13th November 2013

APPLICATION No. N6/2013/1938/MA
PROPOSED COUNCIL OFFICE EXTENSION (AMENDED PLANS)

AN OBJECTION

Title Proposed Sections

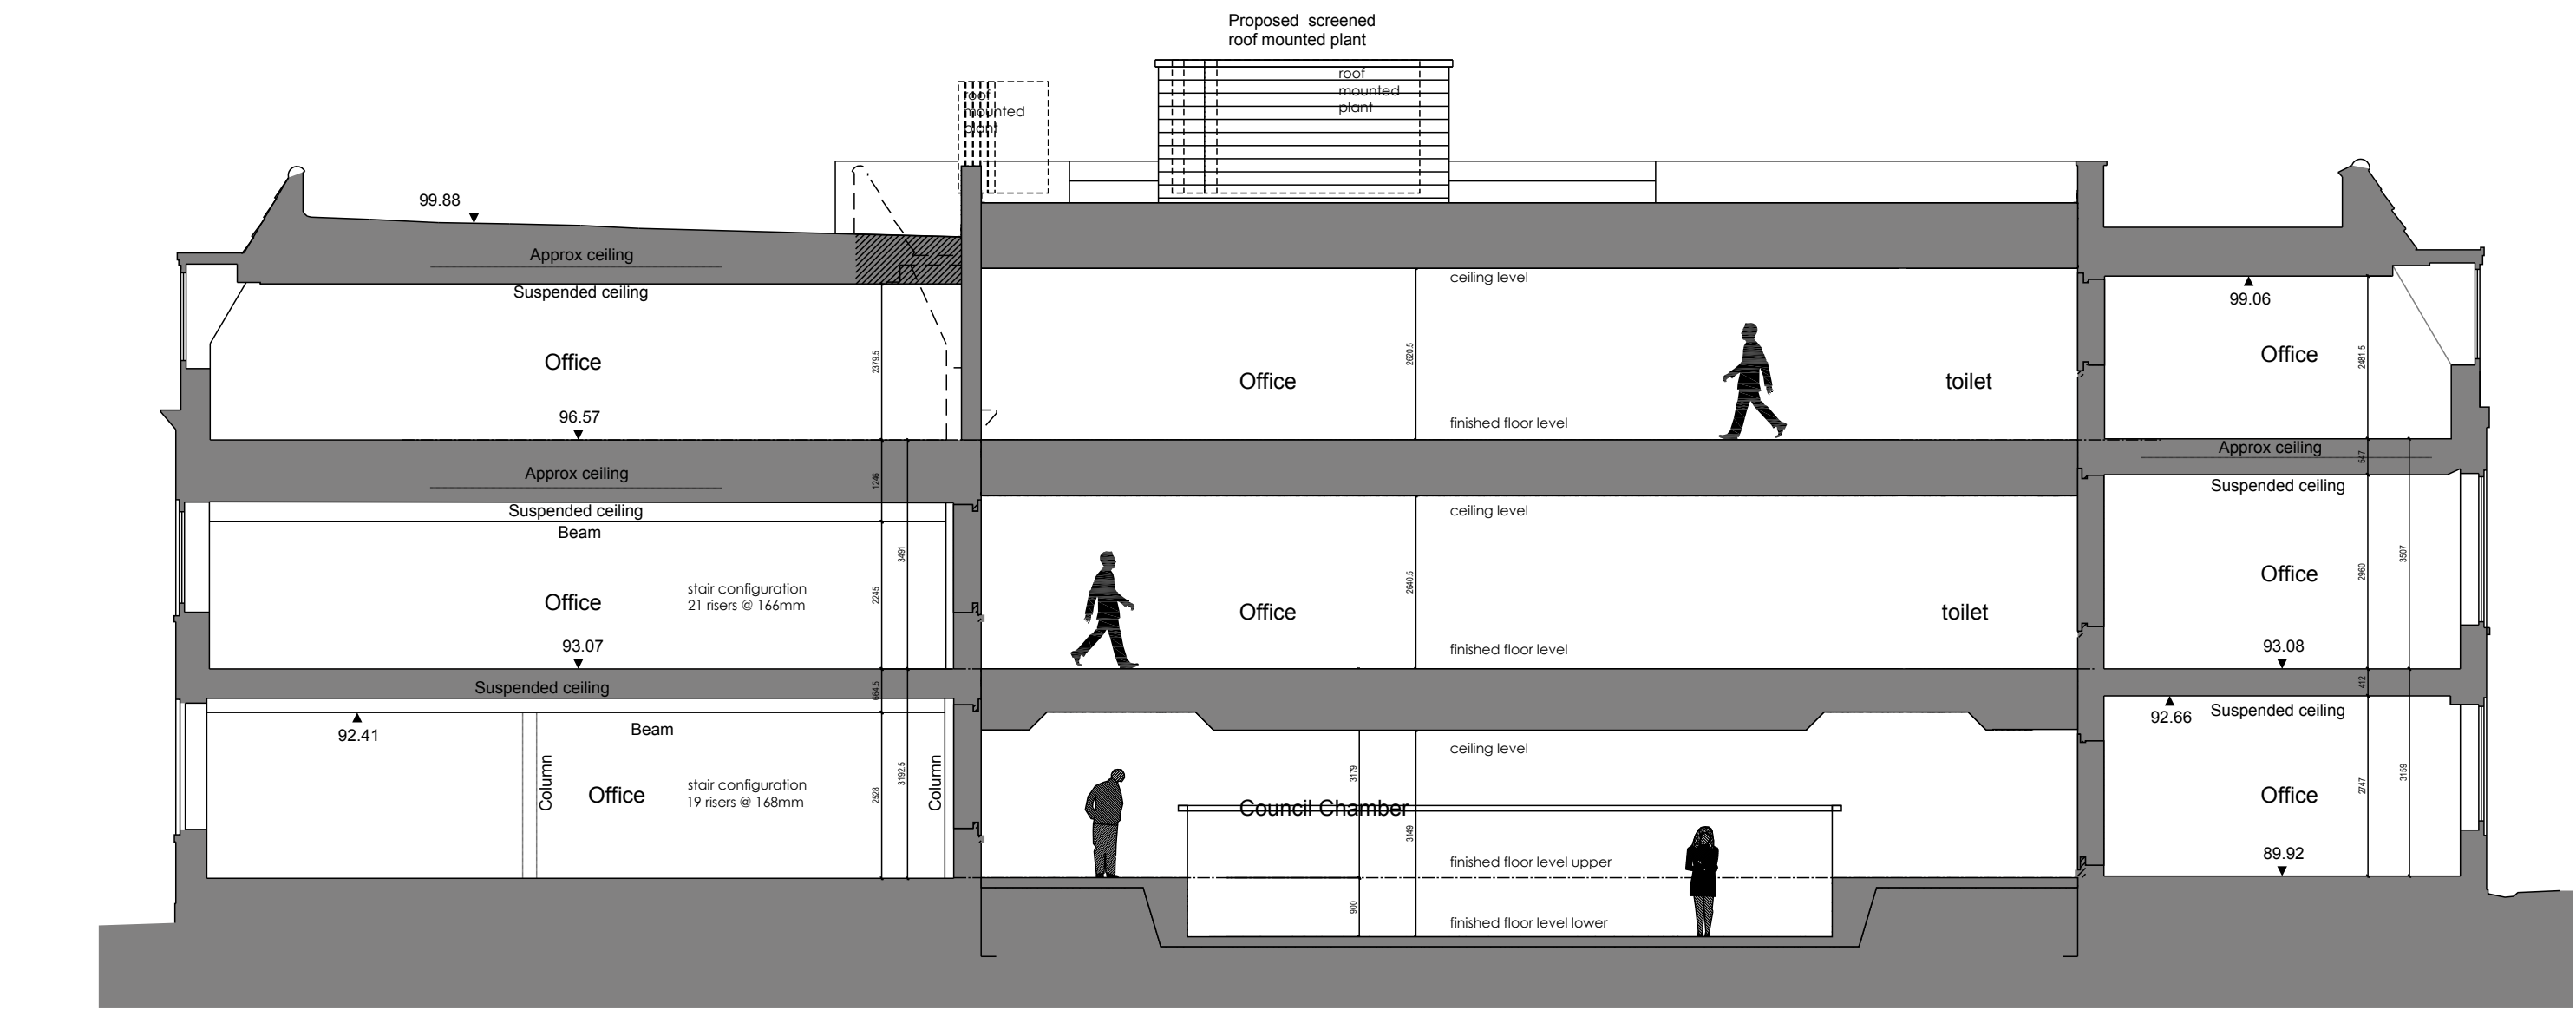
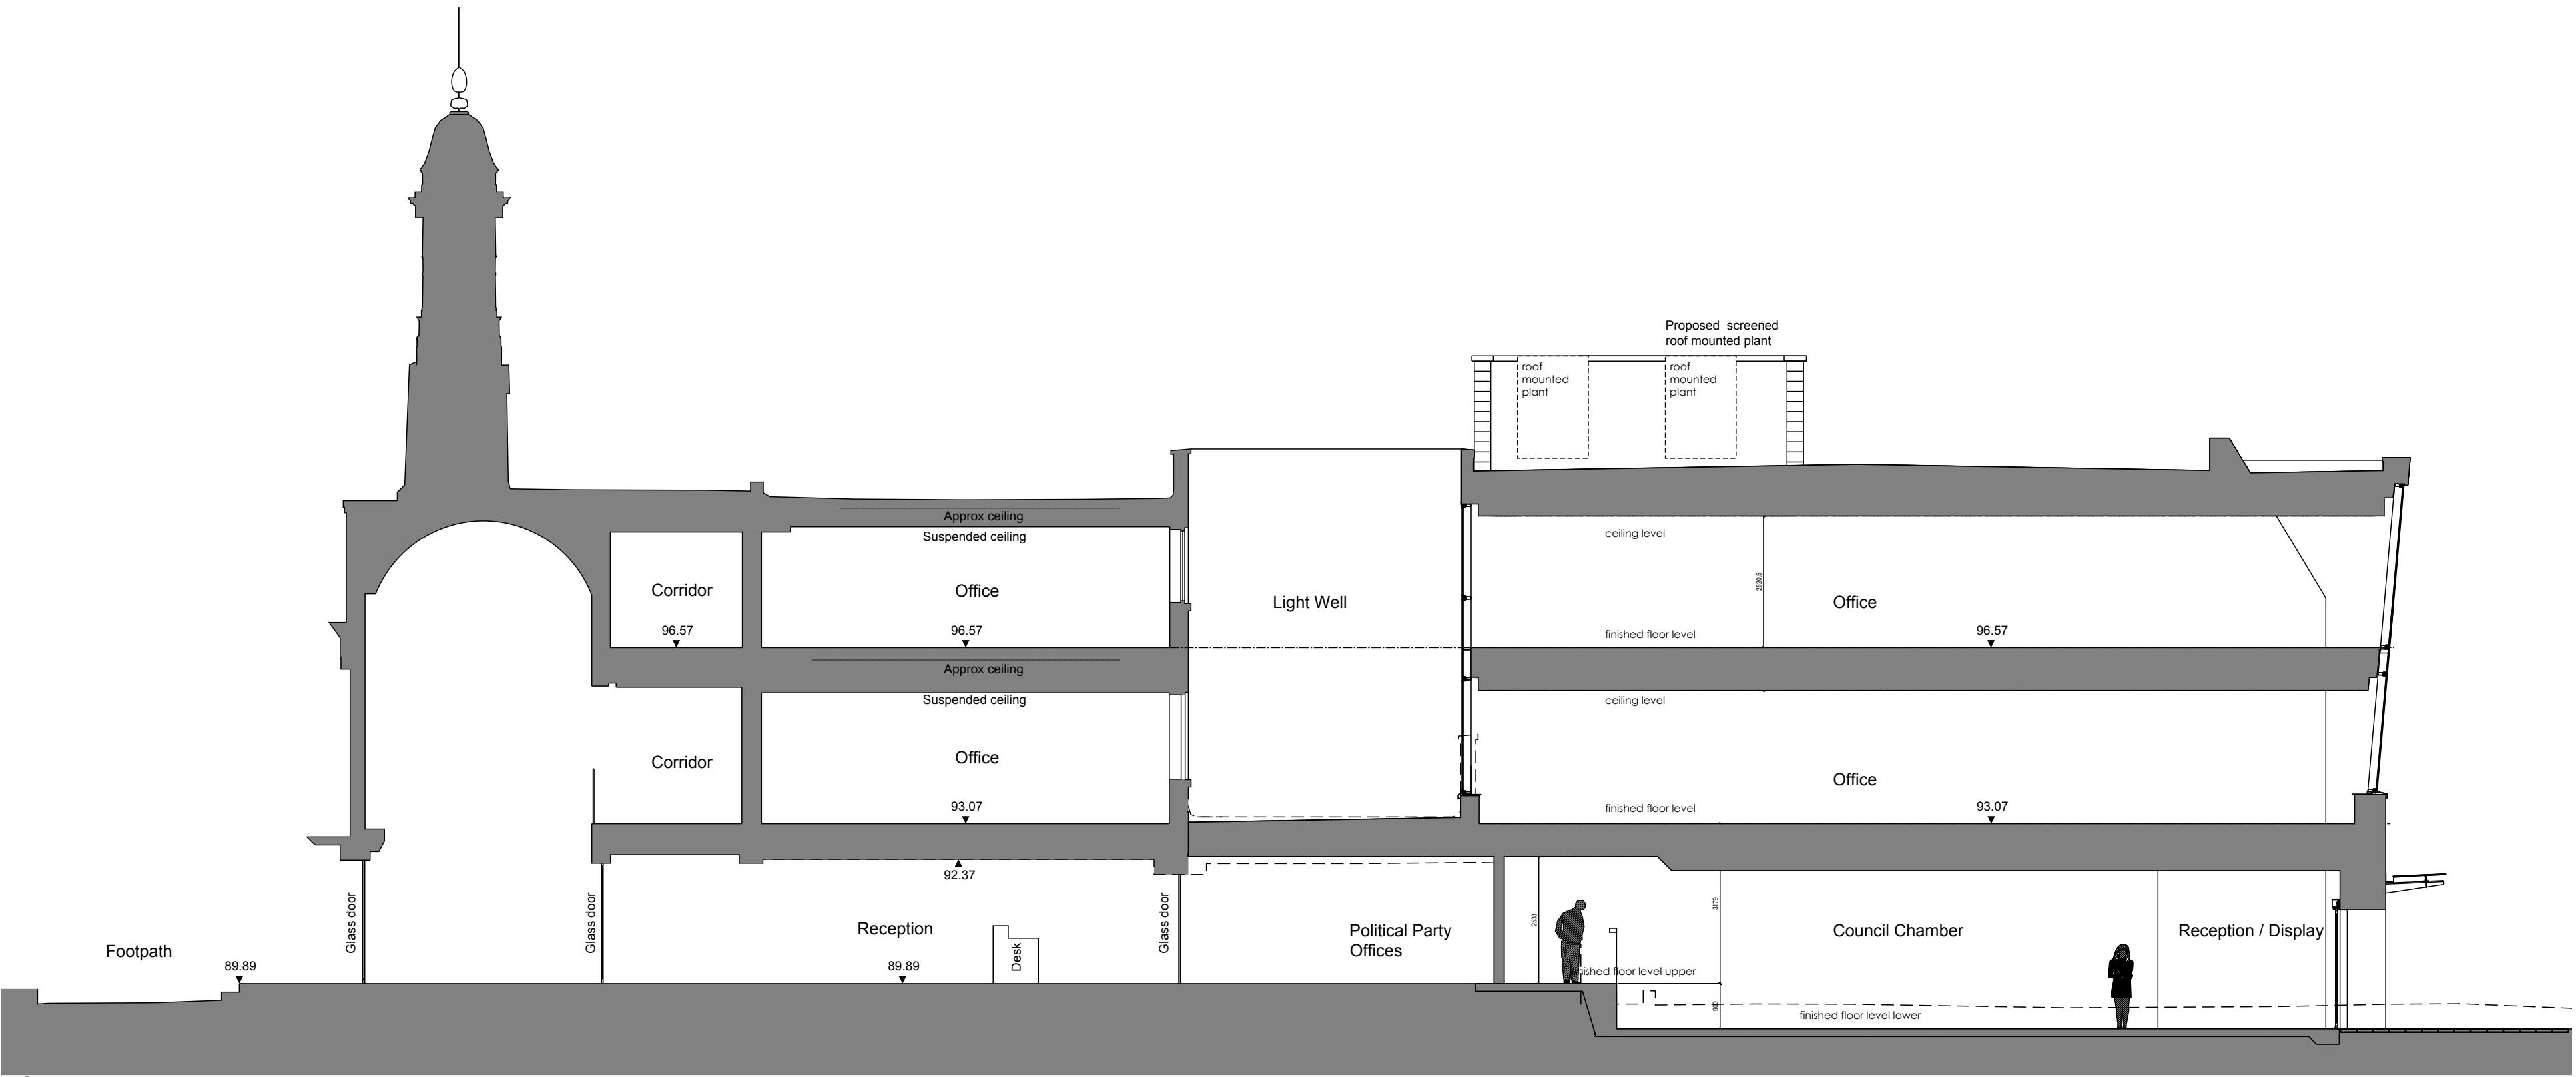
Although set at the rear of the existing building, the extension proposed will be visible in a broad arc of nearly 180 degrees, from College Way to locations in Bridge Road, outside the Waitrose store. This is because there is a large open area to the east of the existing Council building, i.e., the Council's own extensive car park.

Title Proposed Materials

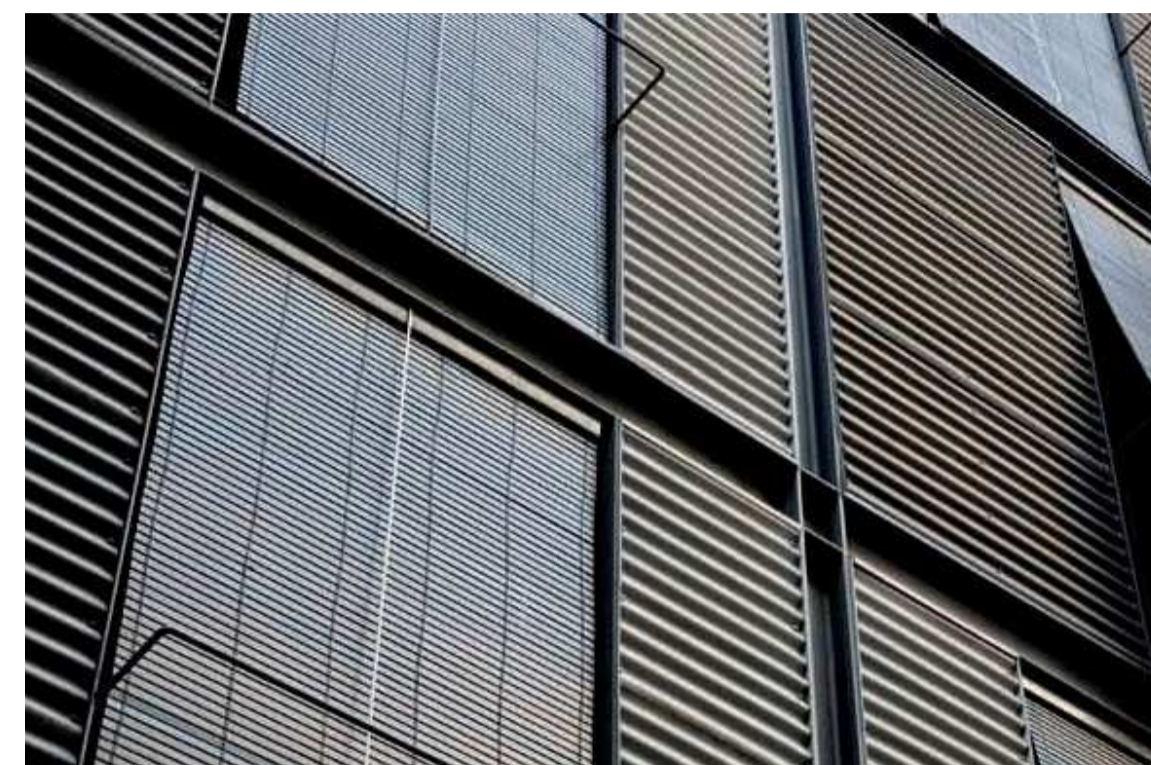
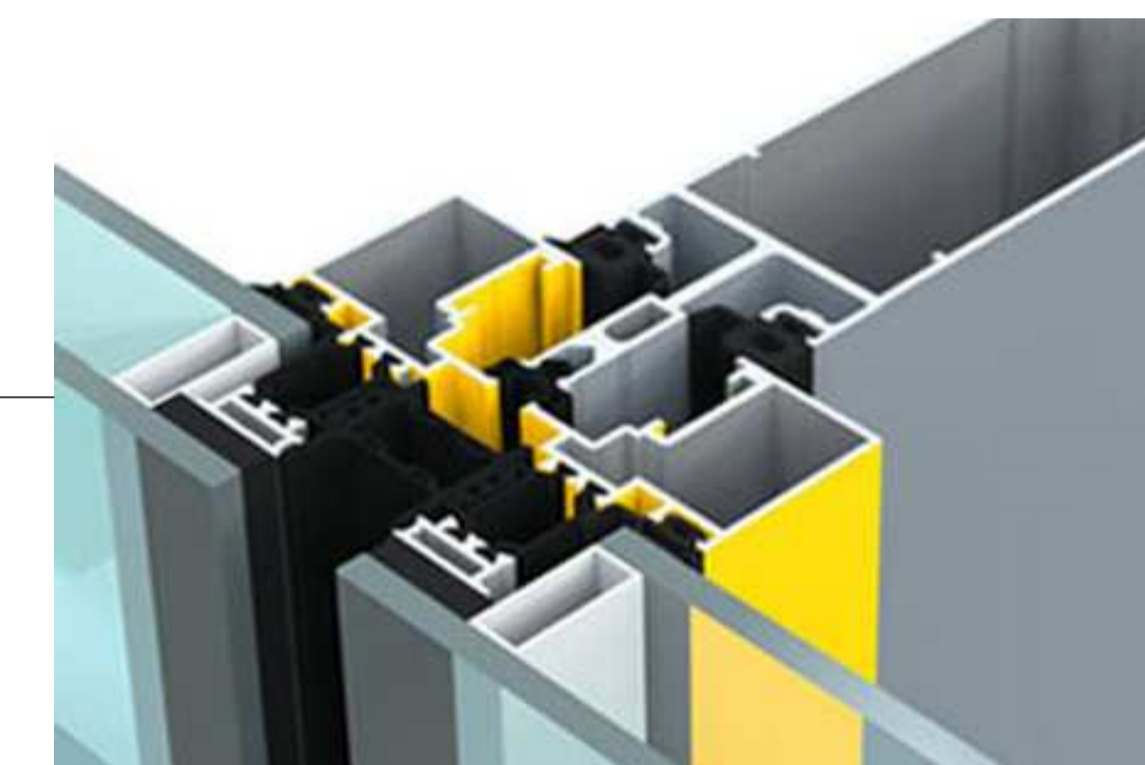
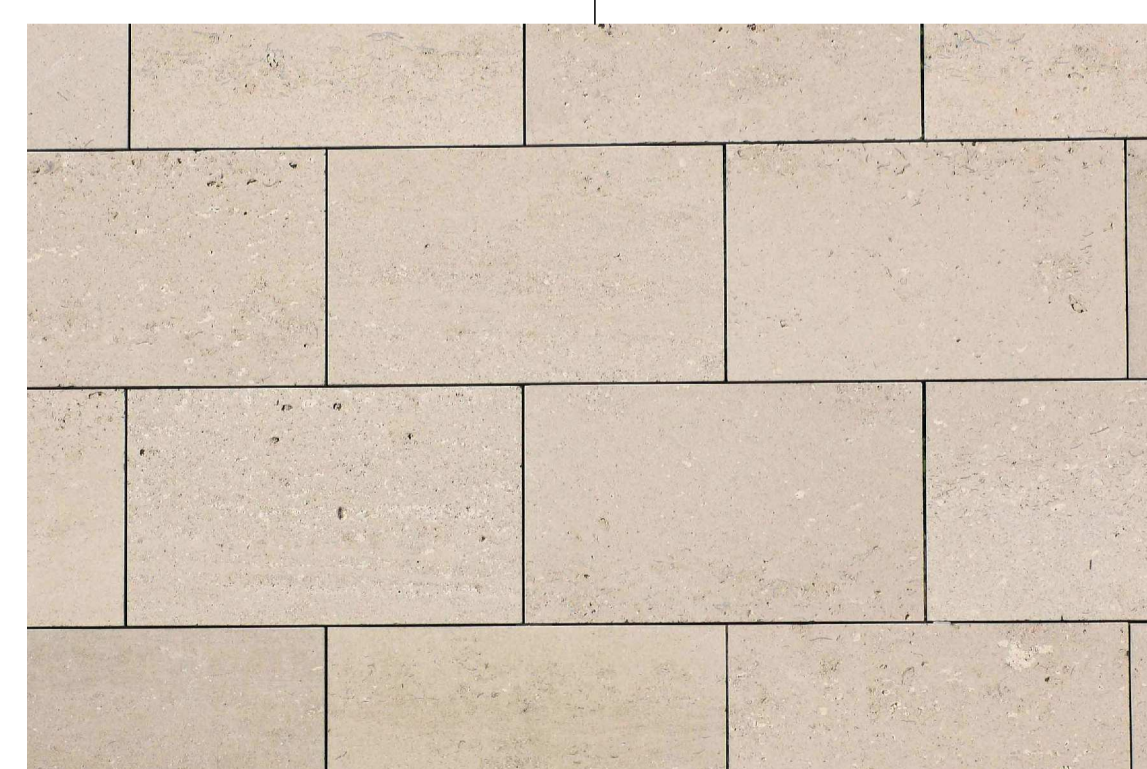
In summary, the exterior design of the proposed extension is inappropriate in the context of the site which is in a Conservation Area, and shows little consideration of, or for, the context, materials, proportions, and scale of the original building. In particular the proposed central glass slab picks up none of the 'key features' evident on the original building:
